Our ref: HA/2020/122437/01-L01
Your ref: CM/25/20/PL
Date: 17 August 2020

EXCAVATION OF POND & CONSTRUCTION OF FLOOD DEFENCE GATES & EARTH BUNDS. CLIMPING COLLEGE, THE MILL CLIMPING STREET CLIMPING BN17 5RN

Environment Agency position

bund planting plan
CM_BP01
Scale: 1:500 + 1:50
Date:16.06.2020

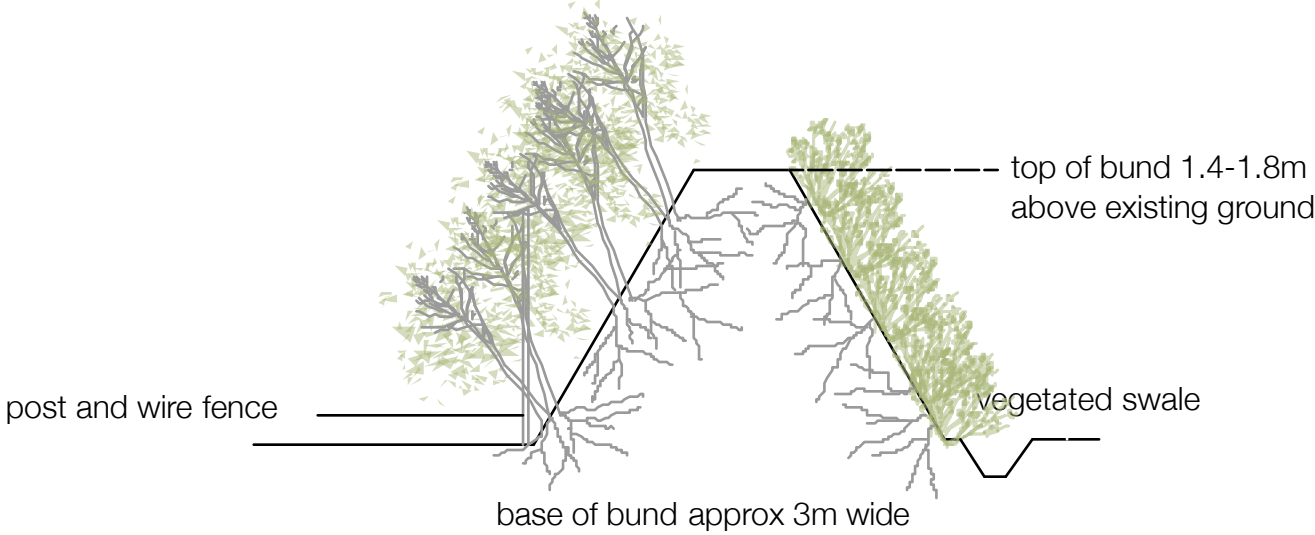
We would advise that consideration should be given to the effects of climate change and sea level rise on the design of the proposed earth bunds and flood gates.
